To Arden District Council - Planning General Enquiries

Planning Application No R/267/17/PL

Thank you for your letter dated 9th August 2018 regarding amendment to the above application.

SECTIONS THROUGH SITE AT 1:200 ON A3

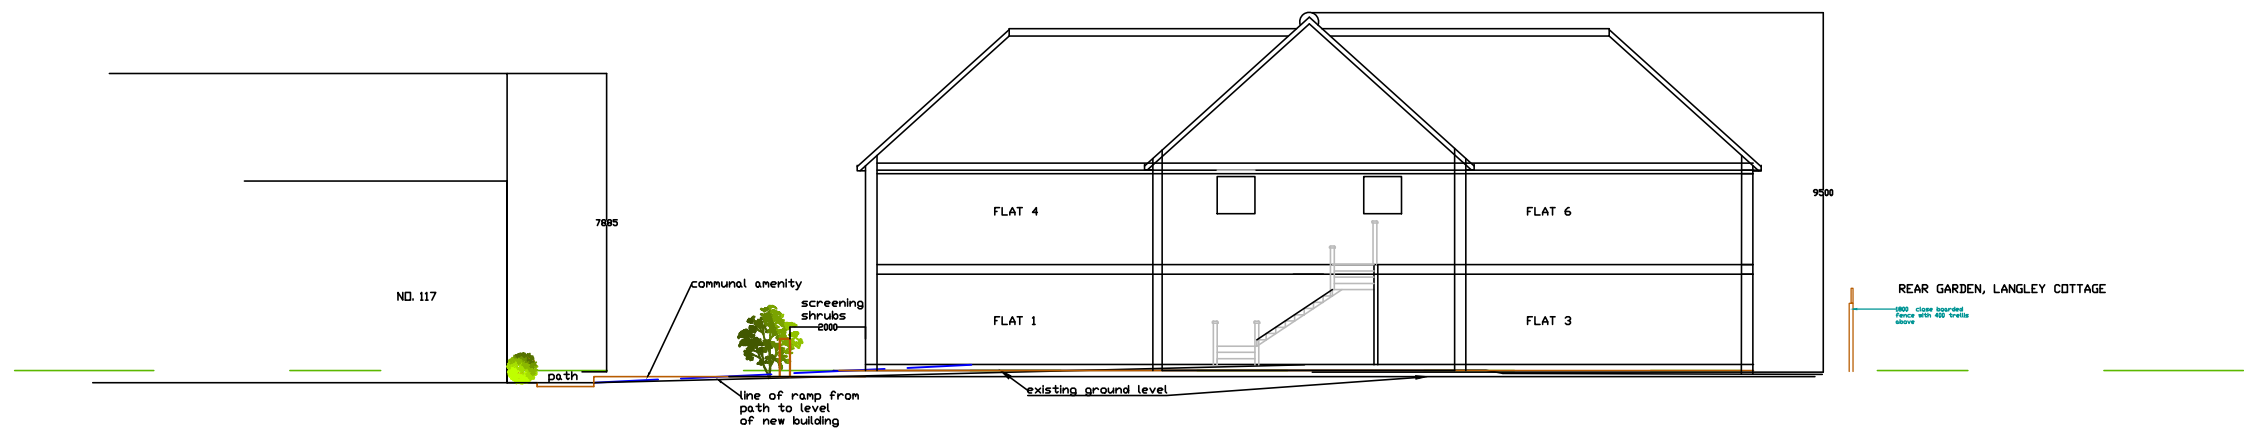
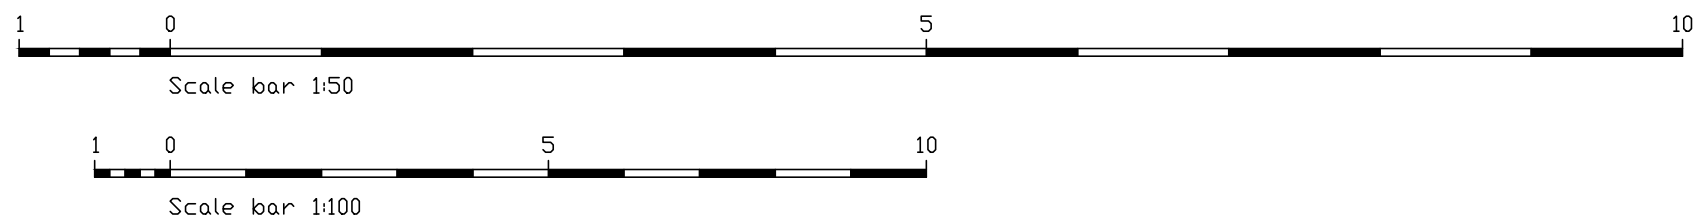
We have noted the lowering of the roof line by 1 metre. Does this bring height of new flats into line with adjacent flats?

Does this amendment mean the roof will become a conventional up and over roof. If it does this would be acceptable.

However if the "Wings" remain this amendment is paying lip service and not addressing our main concern - namely the "Wings". We would still be looking at a 3 storey vertical wall at the end of our garden.

A question: Why is a very large storage area needed in the roof space in this newbuild 2 story block of flats?
